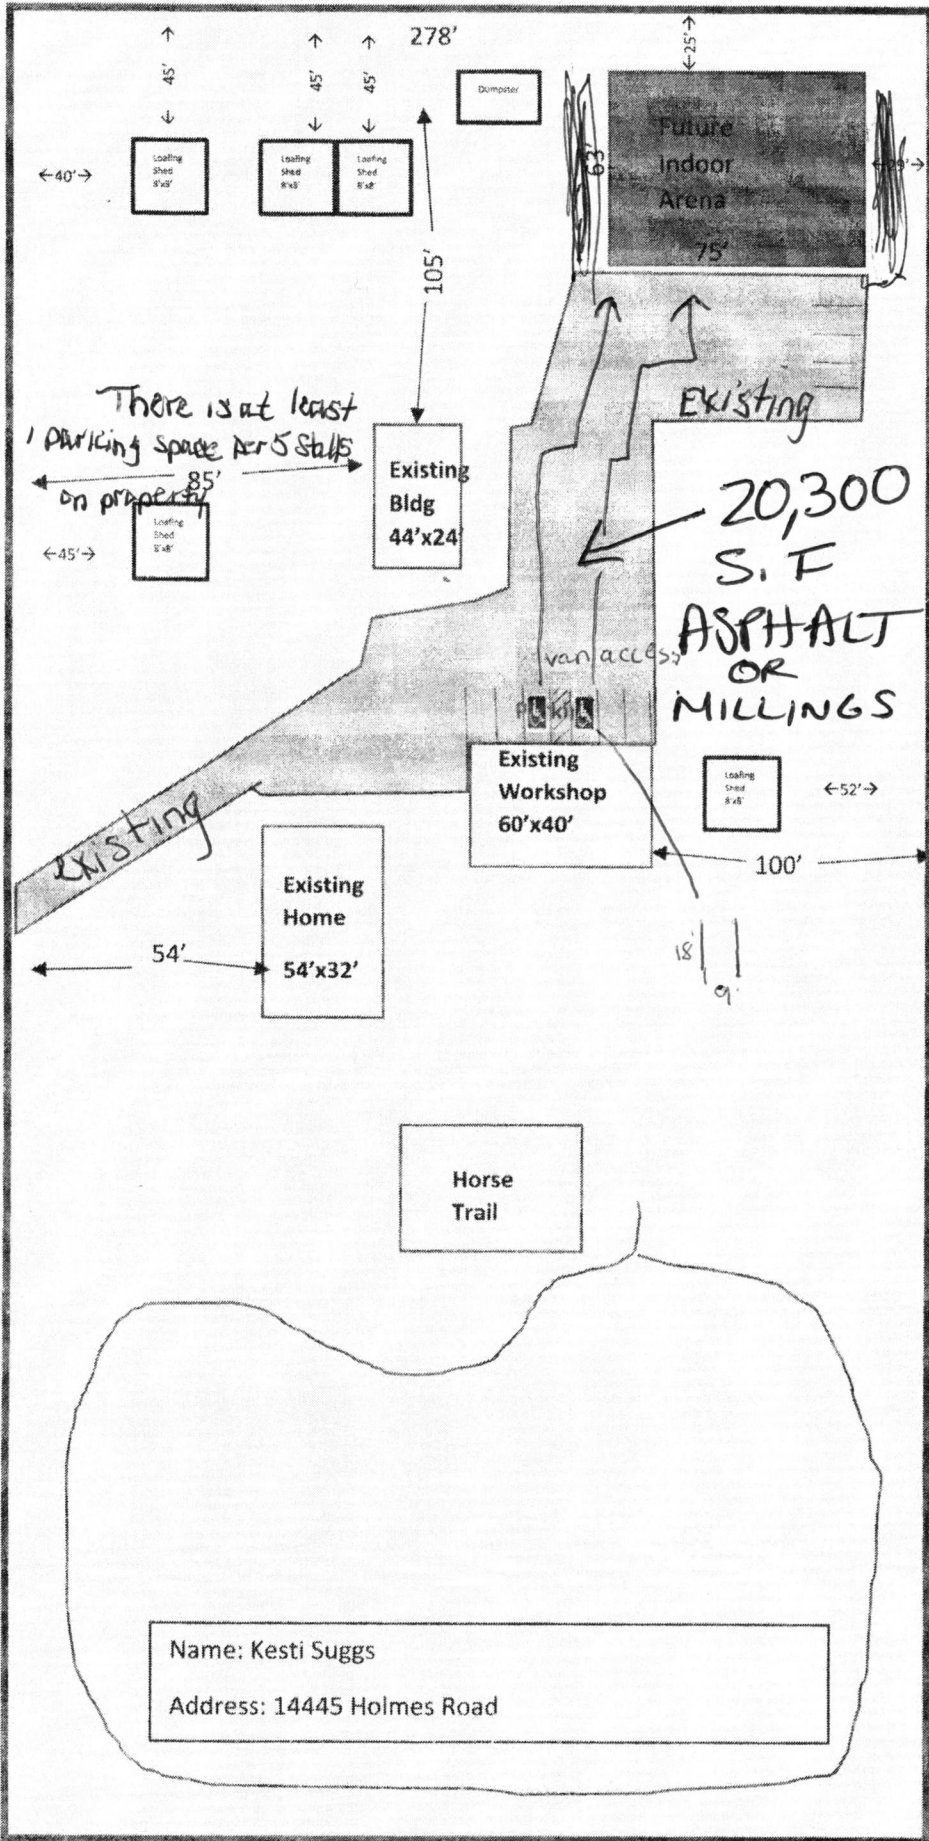
it appears that the building location shown on the drainage plan differs from what is shown on the site plan. Comments were previously made on the drainage plan. Please coordinate so that they match.

If access is proposed onto the private drive on the adjacent property than permission is required from that property owner. Provide access easement that shows that you are allowed to drive through the adjacent property.

Please properly delineate the drive aisles adjacent to the proposed arena. Indicate the surface material of these proposed areas. Also provide dimensions of this proposed area. Is this area included in the 20,300 sq. ft. indicated on the plan? If not then please revise to include this area.

Please identify the proposed 18" culvert shown on the drainage plan

Provide landscape/buffer for north property line. Landscaping must be provided for commercial use adjacent to Residential Development.
